REQUEST

Current Zoning: R-3 (single family, residential)
Proposed Zoning: R-8MF(CD) (multi-family residential, conditional)

Approximately 38.18 acres located along the southwest side of Gibbon Road, east of Statesville Road, and south of Old Statesville Road.

The petition proposes to develop a residential community with up to 287 single family attached dwelling units together with accessory uses.

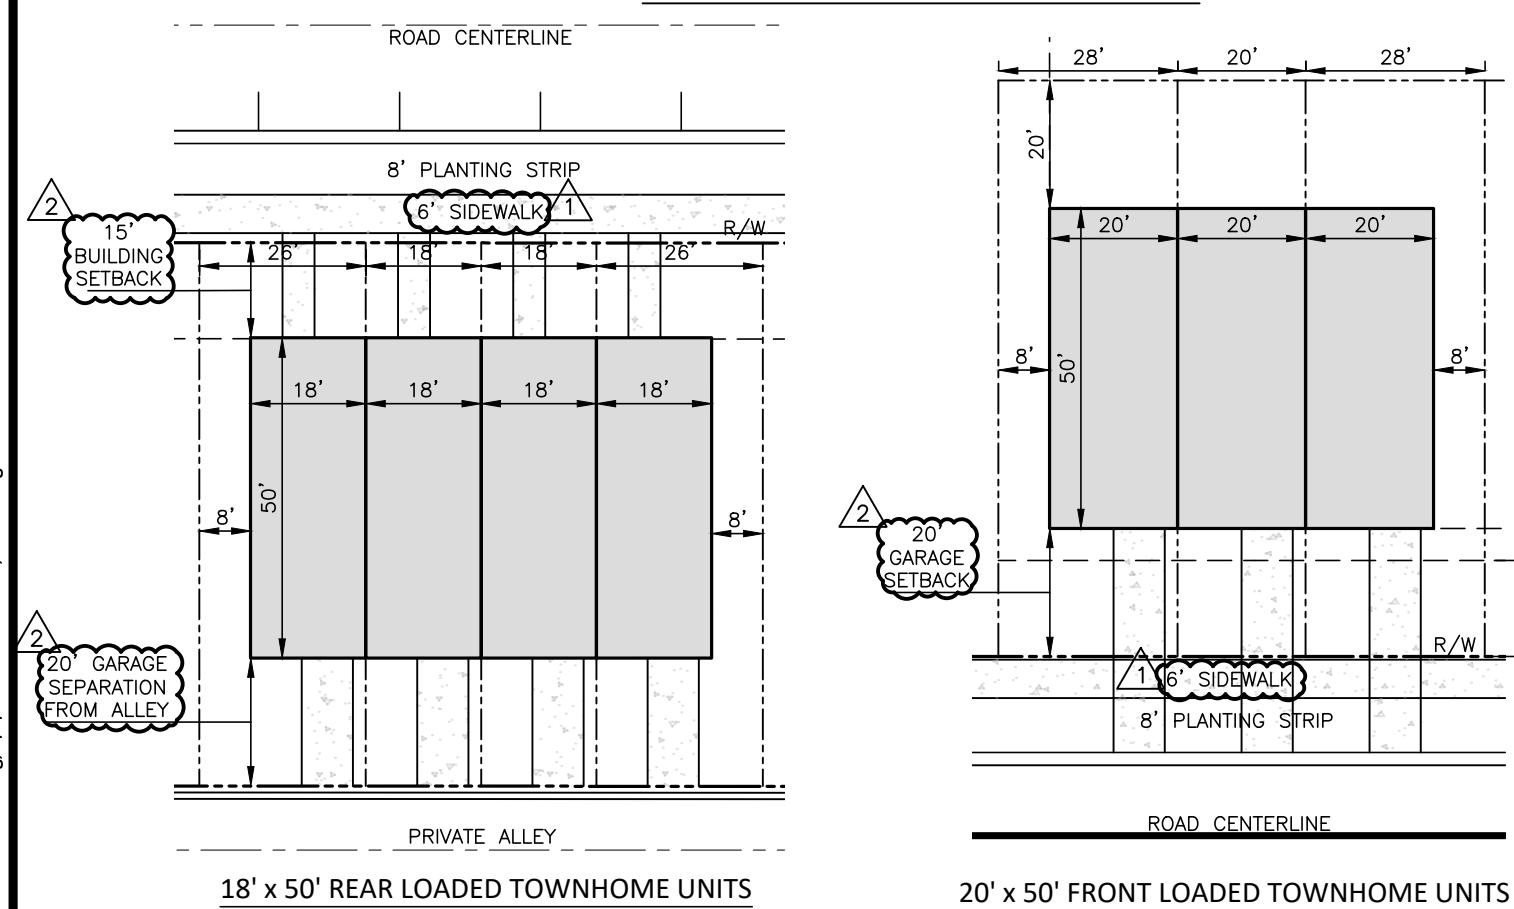
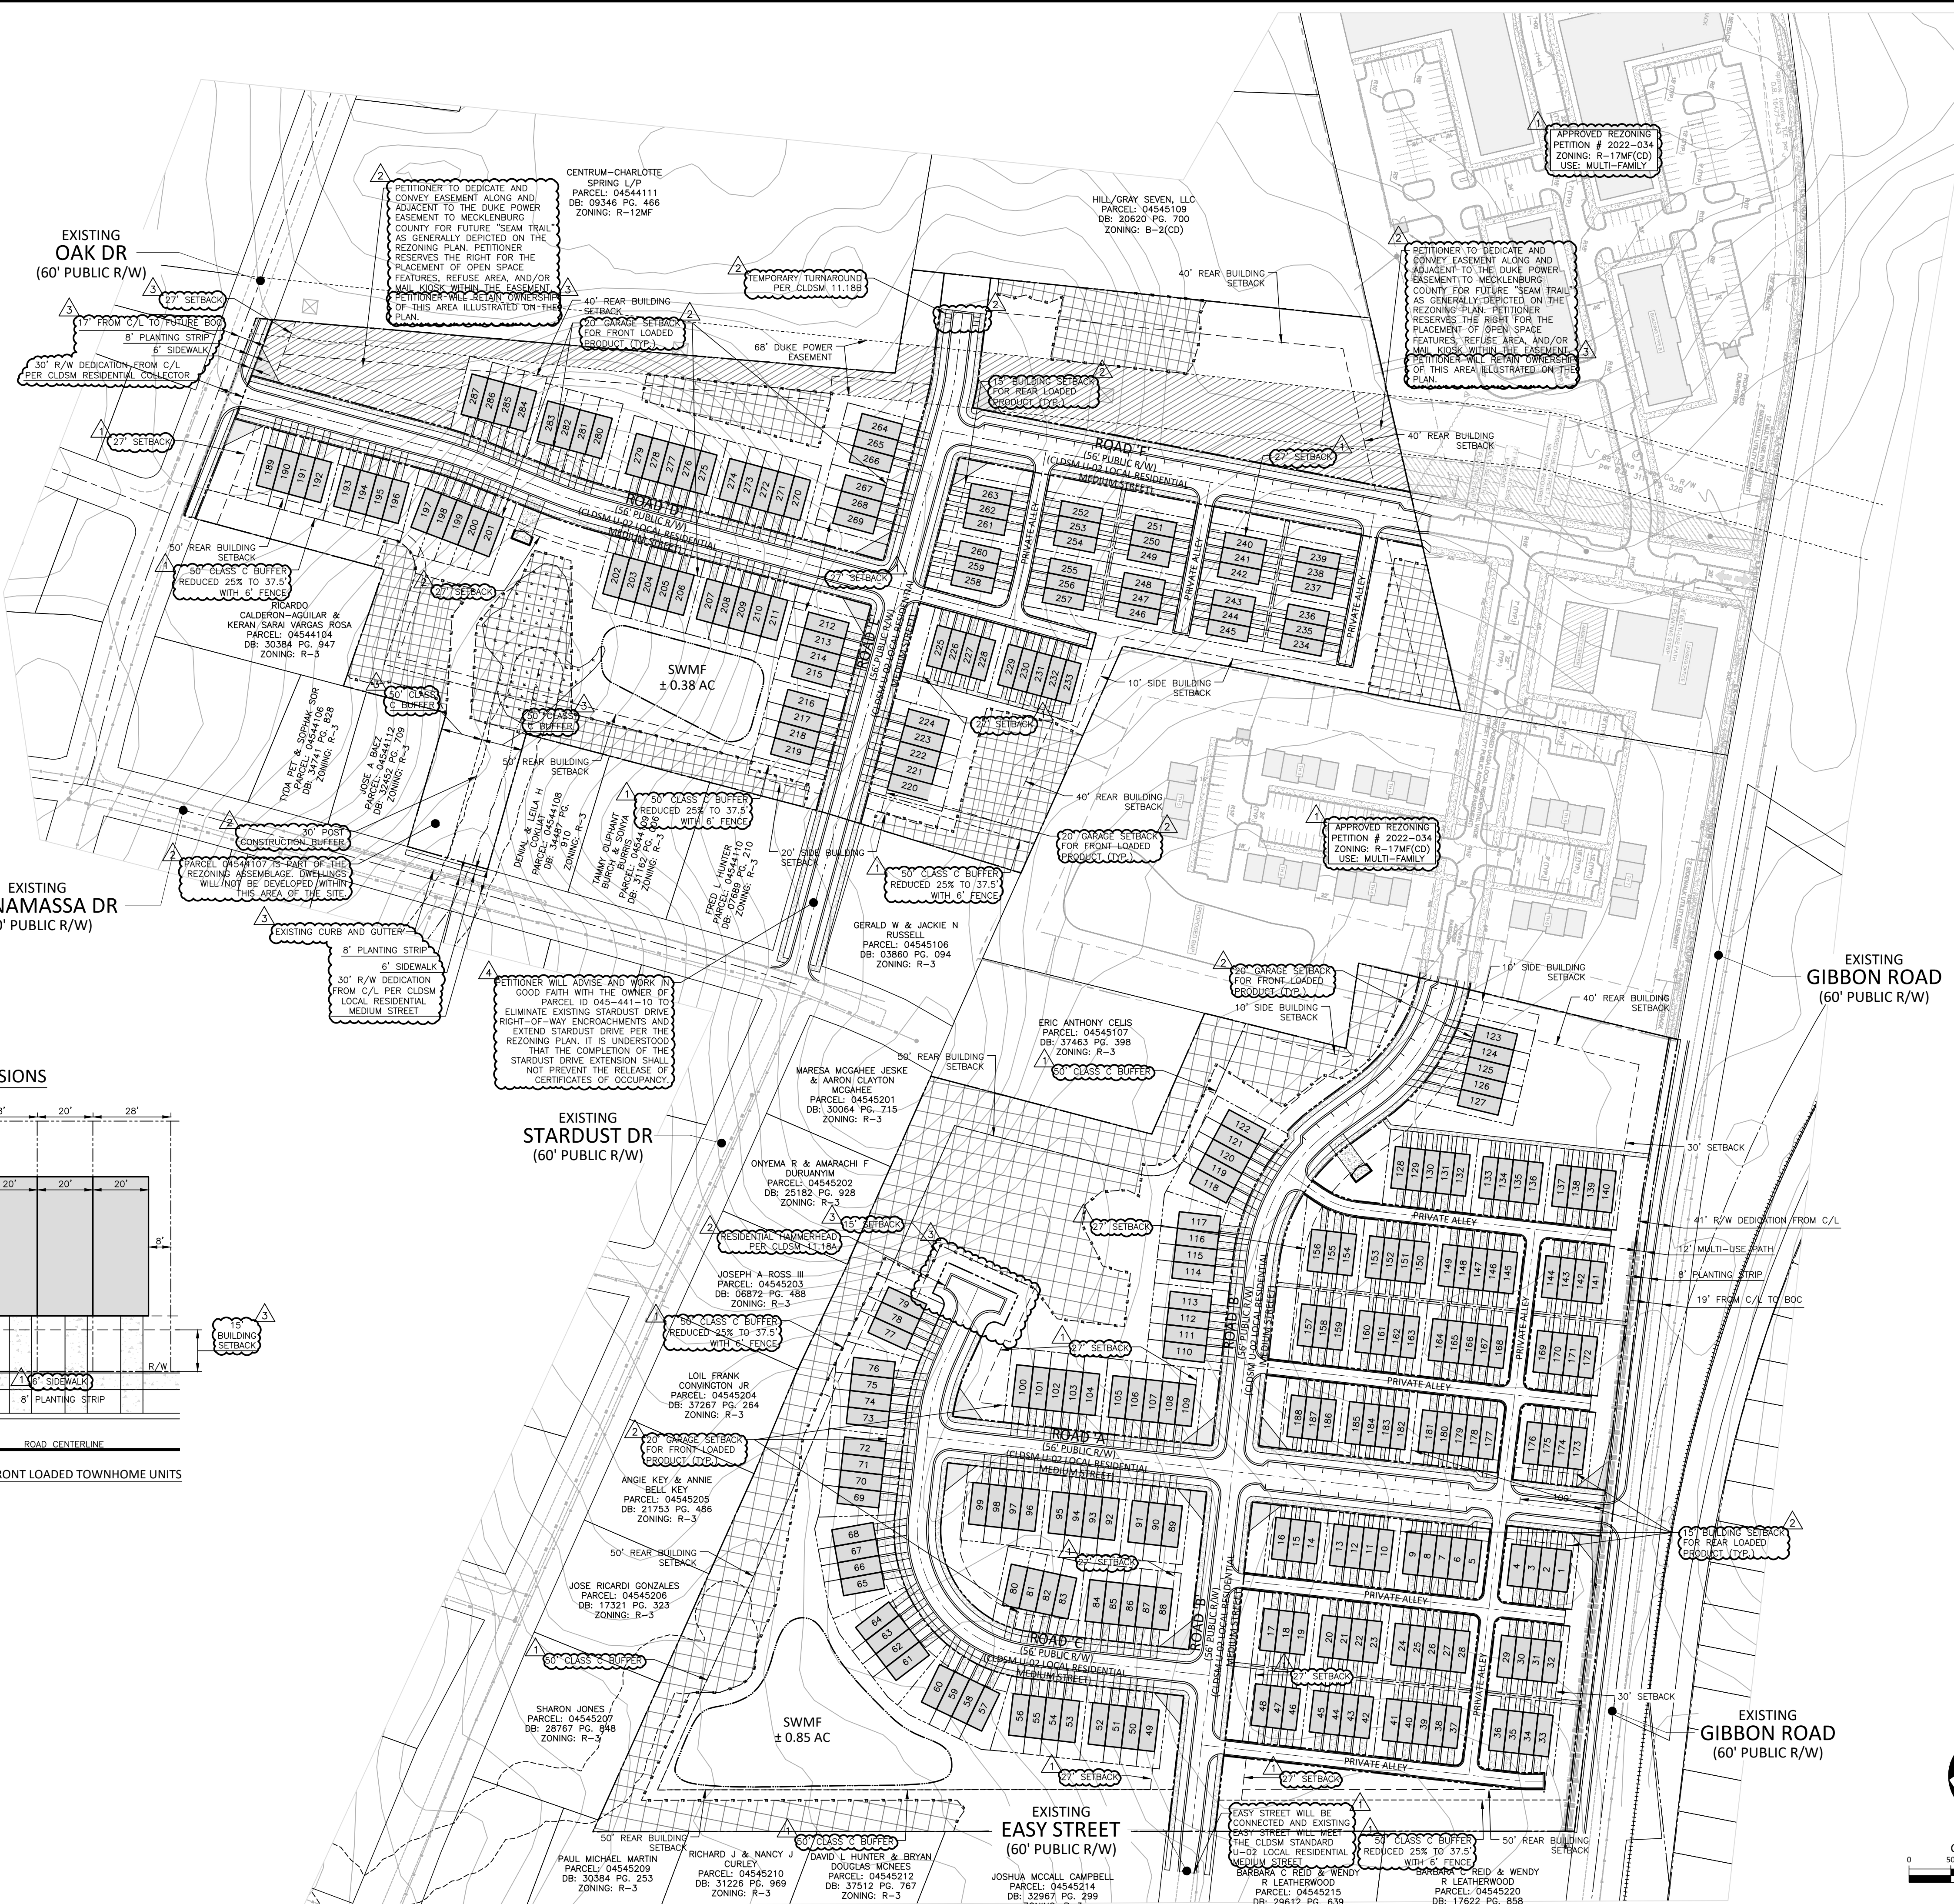
- The site is located on a City-maintained, minor thoroughfare, Gibbon Road. A Traffic Impact Study (TIS) is not required for this site due to the site generating less than 2500 daily trips. Site plan and/or conditional note revisions are needed to remove site plan callout and conditional note stating CDOT will deliver right of way. Further details are listed below.
- **Active Projects:** N/A
- **Transportation Considerations**
 - See Outstanding Issues, Note 5.
- **Vehicle Trip Generation:**
 - Current Zoning:
 - Existing Use: 30 trips per day (based on 3 single family dwelling units).
 - Entitlement: 615 trips per day (based on 58 single family dwelling units).
 - Proposed Zoning: 2,140 trips per day (based on 287 single family attached dwelling units).

5. ~~Revise site plan and conditional note(s) by removing callout from site plan and conditional note 3.k.~~
